The Member-Secretary
Chennai Metropolitan Develop-
ment Authority
1, Gandhi Irwin Road
Egmore, Chennai 600 008

Letter No. A2/37189/2004

Sub: CMDA - Planning Permission - Construction of Ground + First Floor Residential building with two dwelling units at Pilliyar Koil 4th Cross Street, Chennai 600 096 in S.No.78/2-1A2 of Perungudi village - Development charges and other charges to be remitted - Reg.

SITE PLAN SCALE-1:200

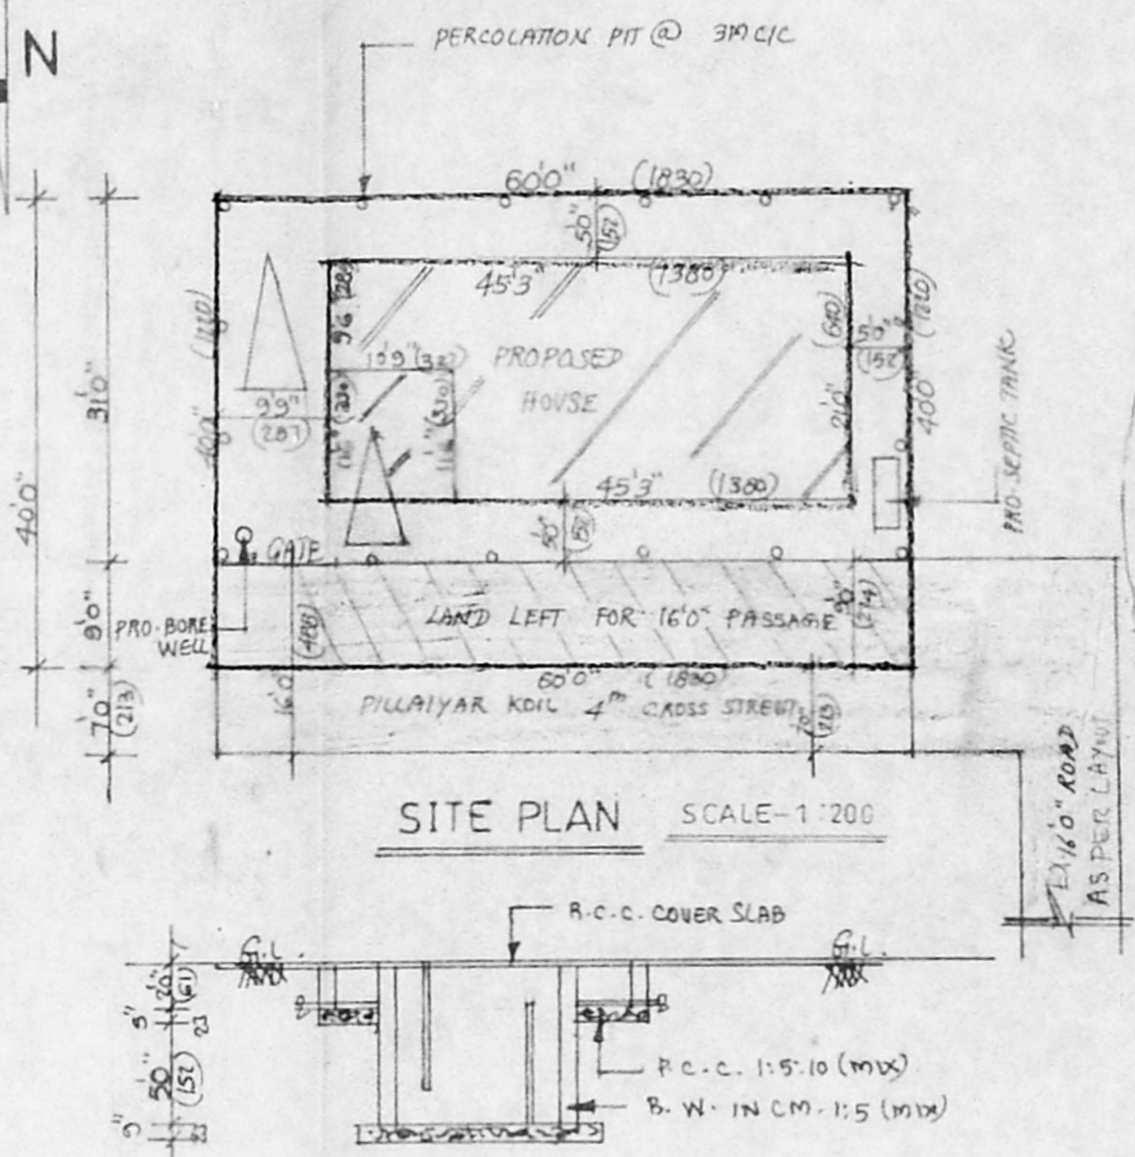
- a. Rain Water conservation Regulations stipulated by CMDA should be adhered to strictly.
- b. Five copies of revised plan showing the gate at proper position to park the car in the provided lots.
